**WELWYN HATFIELD BOROUGH COUNCIL  
EXECUTIVE DIRECTOR - PLANNING, PUBLIC PROTECTION AND GOVERNANCE**

**DELEGATED APPLICATION**

**Application No:** 6/2018/3255/FULL  
**Location:** Plot 5610, Gypsy Moth Avenue, Hatfield Business Park, Hatfield, AL10 9BS  
**Proposal:** Erection of a pre-delivery inspection facility (Use Class B2), together with car storage area (Use Class B8), staff car parking, cycle parking, boundary treatment, landscaping, lighting and access  
**Officer:** Mr David Elmore  
**Recommendation:** Granted

6434 - 008
 PLANNING

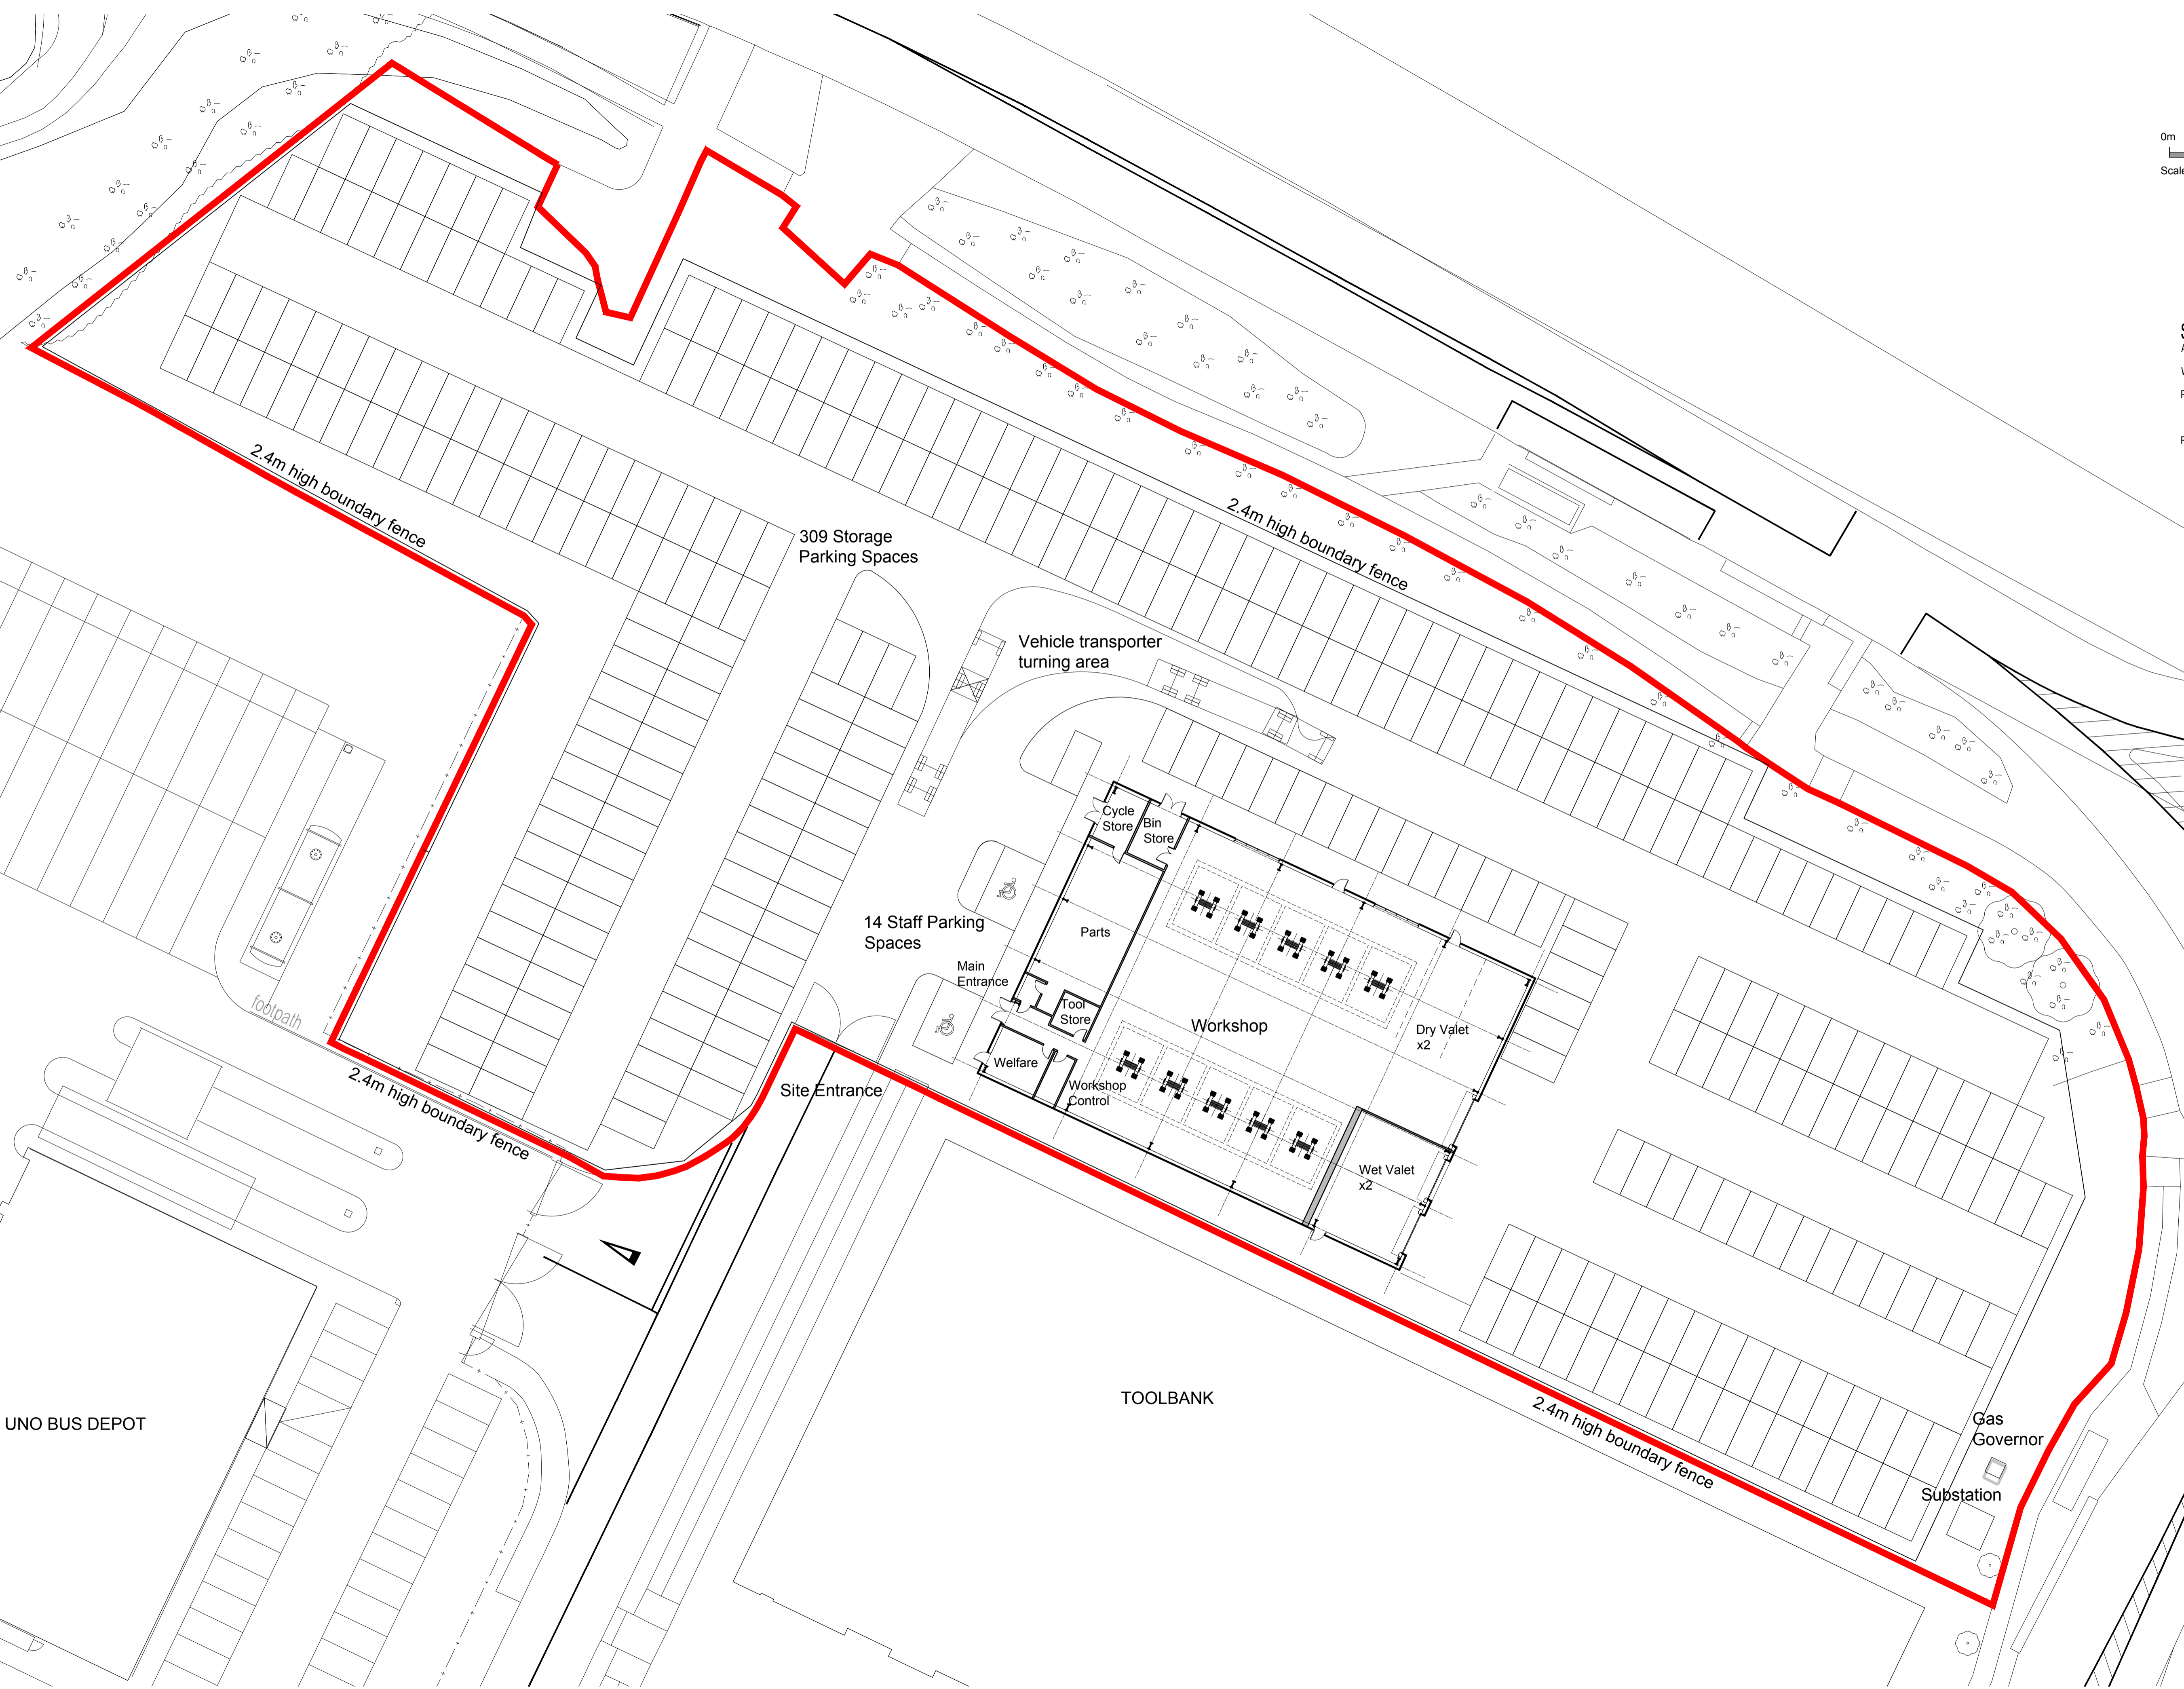
Much of the site would be laid in hard-surfacing to facilitate the storage of up to 309 vehicles which is considerable. It is considered however that the extent of vehicle storage would not appear harsh or incongruous in this location. Existing perimeter landscaping provides a degree of site screening. This screening together with the proposal to provide a strong line of trees on the site boundaries fronting Hatfield Avenue and Gypsy Moth Lane would effectively mitigate the impact of the development proposal in visual amenity terms. The submitted planting plan shows an appropriate mix and density of native trees.

The application description includes boundary treatments, cycle parking and lighting, however limited details of these elements of the proposal have been provided. Precise details can be secured through planning conditions.

In terms of car parking provision, the development would provide 14 staff car parking spaces (and 2 disabled spaces). The Hatfield Aerodrome SPD advises an end ratio of 1 space per 60sqm of floorspace which equates to a total of 17 spaces. Whilst this represents an under-provision of on-site parking provision the site is located within reasonable walking distance from local bus stops, each provided with shelters. Bus routes include connections with Hatfield Rail Station some 2km away (service 600). The site will also include cycle provision (subject to condition) to further provide sustainable transport options. A development of this scale would require 3 long term cycle parking spaces. In addition, it is understood that the 24 employees will be subject to shift working and therefore, not all 24 employees will be working on site at any one time. It has also been explained by the applicant that the 300+ parking spaces for storage would not be fully occupied all the time, due the peaks and troughs in deliveries. Therefore the site will be able to accommodate additional staff car parking should there ever be the demand for more than the staff parking spaces.

5. No development above ground level shall take place until details of a cycle parking area for 3 bicycles has been submitted to and approved in writing by the Local Planning Authority. These details include:
  - a) Elevations (front, sides and rear) to a metric scale illustrating the size, form and openings. The type, colour and manufacture of the external materials must also be annotated;
  - b) Floor plan to a metric scale showing footprint and openings;
  - c) Roof plan to a metric scale including annotation of type, colour and manufacture of the roof covering; and
  - d) Block plan to a metric scale showing location of cycle store within the site.

7. Prior to use of the development hereby approved, precise design details of the 2.4 metre boundary fencing has been submitted to and approved in writing by the Local Planning Authority. These details must include external material type and colour. The development must then be implemented in accordance with the approved details.

**EXTERNAL LIGHTING LAYOUT**

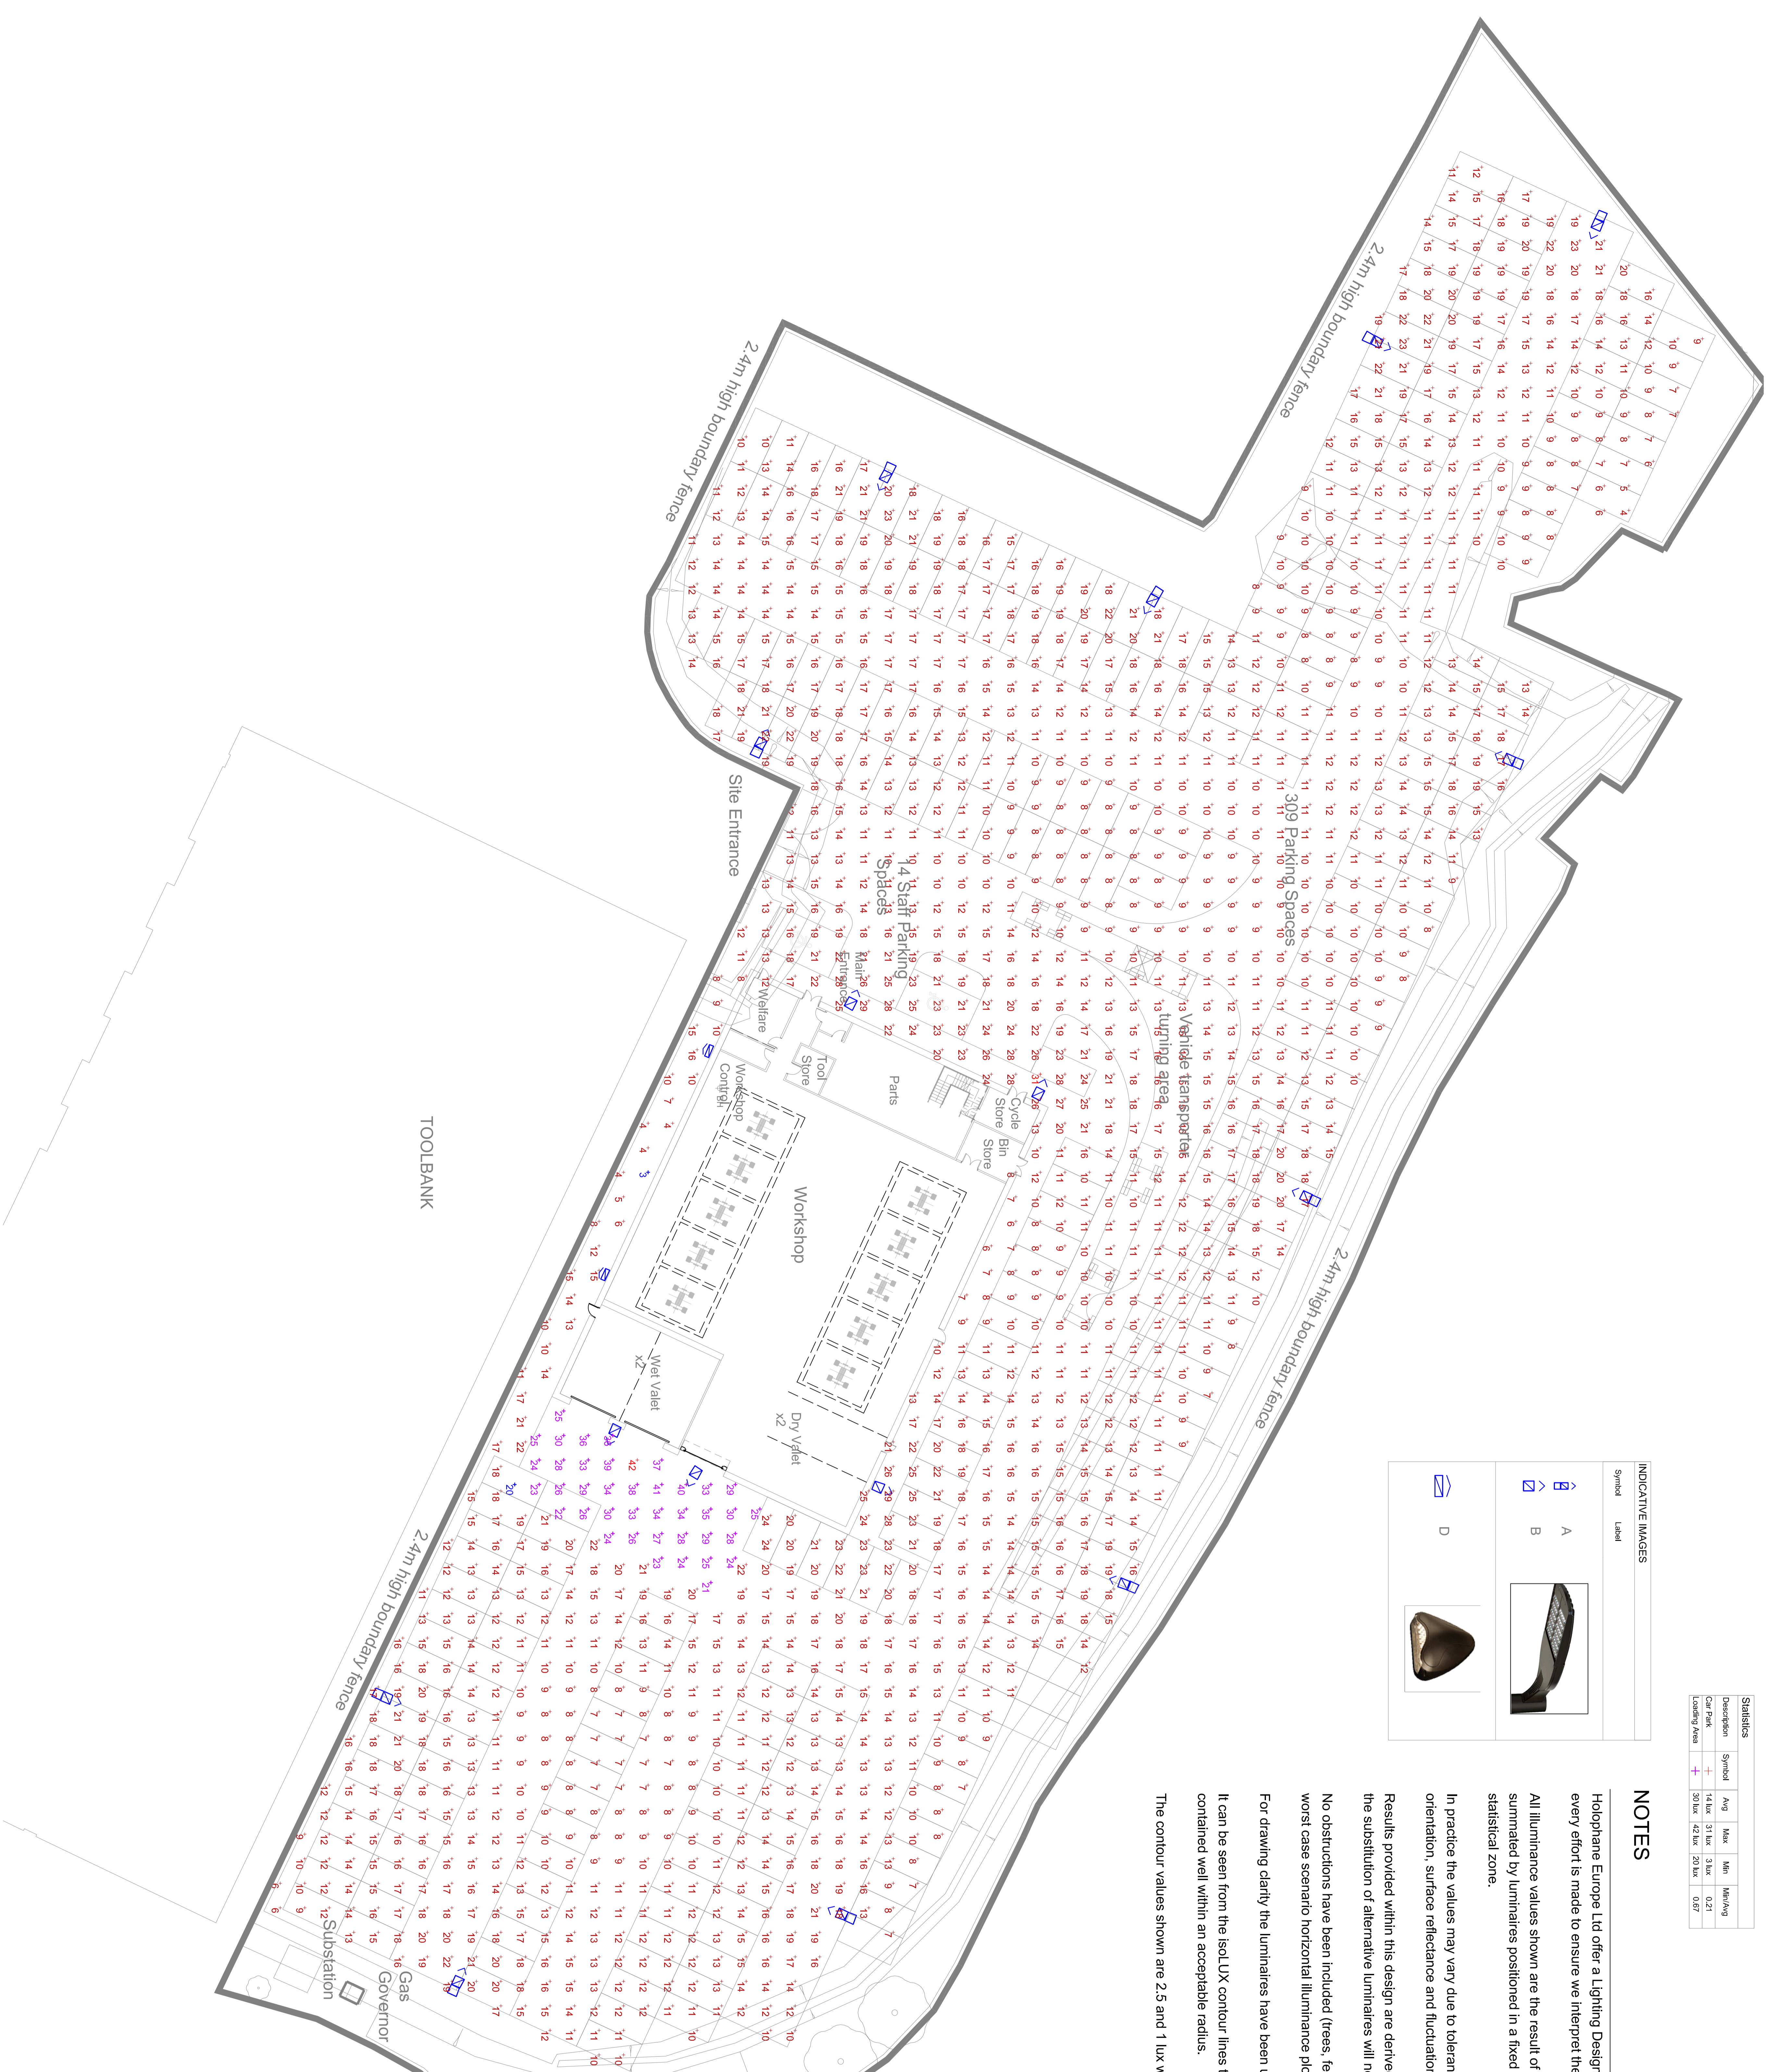
Limited details of external lighting have been provided with this application, however precise details

are appropriate through a planning condition.

10. Prior to use of the development hereby approved, the following external lighting details must be submitted to and approved in writing by the Local Planning Authority:

- a) Elevations of lampposts (metrically scaled)
- b) Vertical lux diagrams which show potential light trespass into windows of nearby residential properties. This scheme must meet the requirements within the Institution of Lighting Professionals guidance notes for the reduction of obtrusive lighting.

The approved details must be implemented in accordance with the submitted External Lighting Layout plan submitted and received 20 December 2018 and with drawing number: P5610-SPIE-XX-XX-DR-X-3000 Rev P02. No other external lighting shall be installed without prior consent from the Local Planning Authority.
